PLANNING AMENDMENT

Application No: H16-0620-11 | A1

Description: Erect 130 dwellings, comprising two-storey and two-and-a-half storey houses and maisonettes (outline appeal decision H16-0578-01)

Proposed Reserved Matters Submission for Residential Development of 130 Units – Wygate Park South, Wygate Park, Spalding

LAND AT WYGATE, SPALDING - LANDSCAPING MASTERPLAN (1:500)

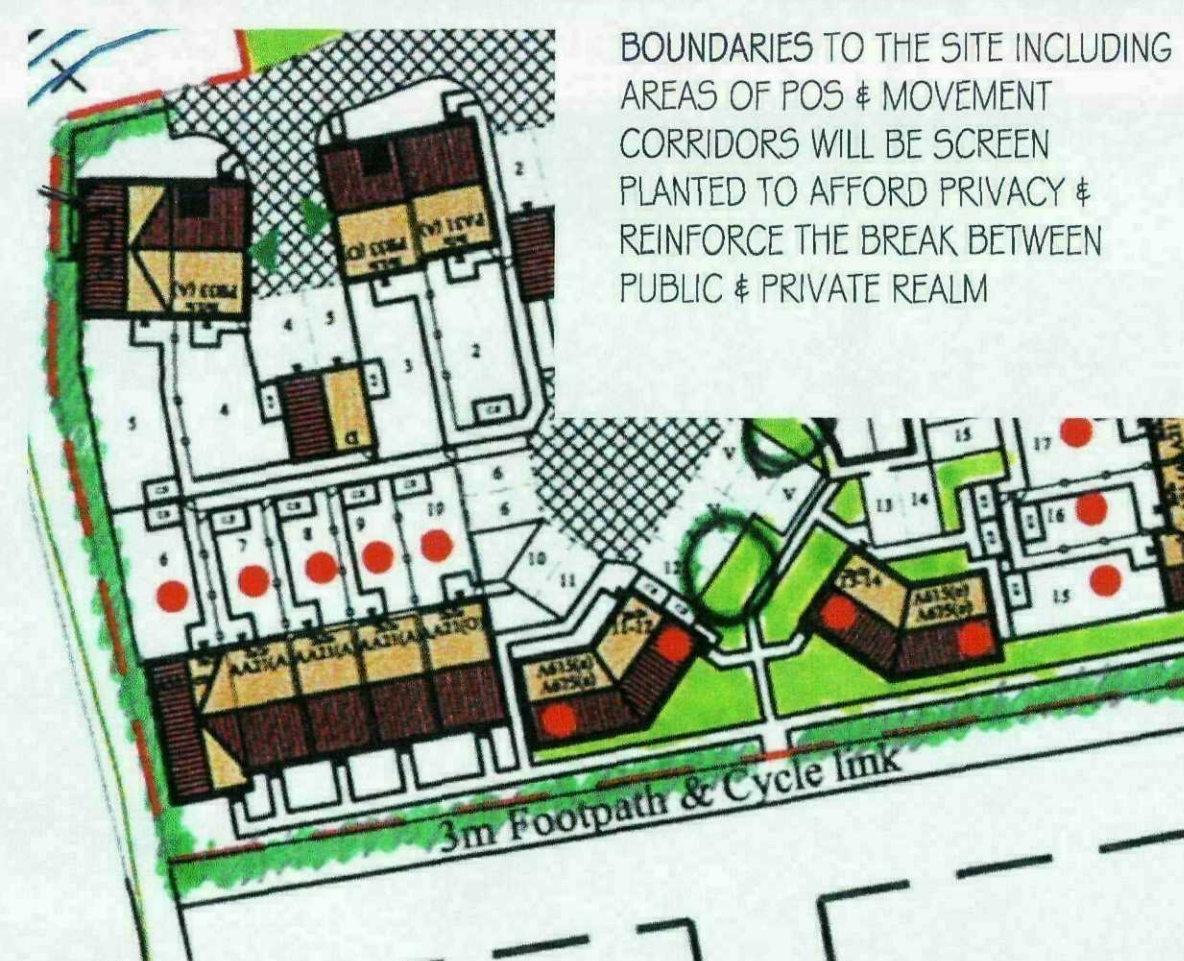
As discussed, we have received consultation feed back from the Welland & Deepings internal drainage board. The enclosed layouts are revised in response to their comments on the original scheme. In particular the need for a 9 metre easement to the existing dyke that runs along the western boundary, and also the need to remove the maintenance issue of the open ditch along the northern boundary.

The main changes to the scheme are therefore the re plan of plots 21 to 93 to accommodate both the 9 metre easement and the inclusion of the piped northern ditch into the rear gardens where adjacent. This has lead to the re orientation of several plots to back onto the northern boundary and the removal of two cul-de-sacs to be replaced by a loop road.

LAND AT WYGATE, SPALDING - D1117 FLOOR PLANS (1:100)

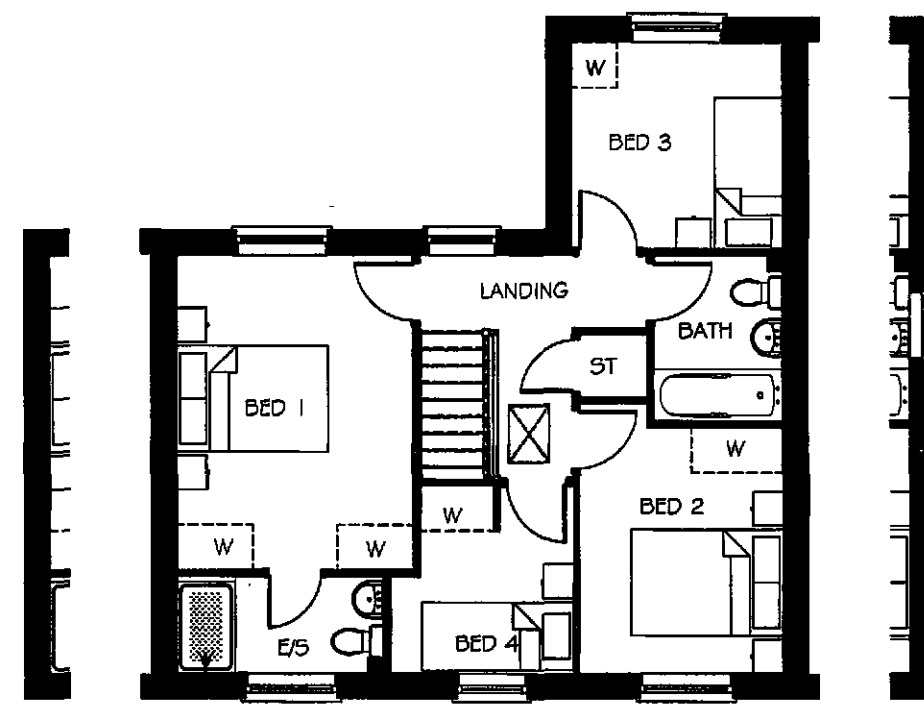
In addition to the revised layouts, I have also included a set of revised house types that include the additional windows required to police adjacent and rear drive areas. The additional window locations are also indicated on the layout plan by green triangle symbols. A drawing of the lean-to roof to plot 23 has also been added to the package.
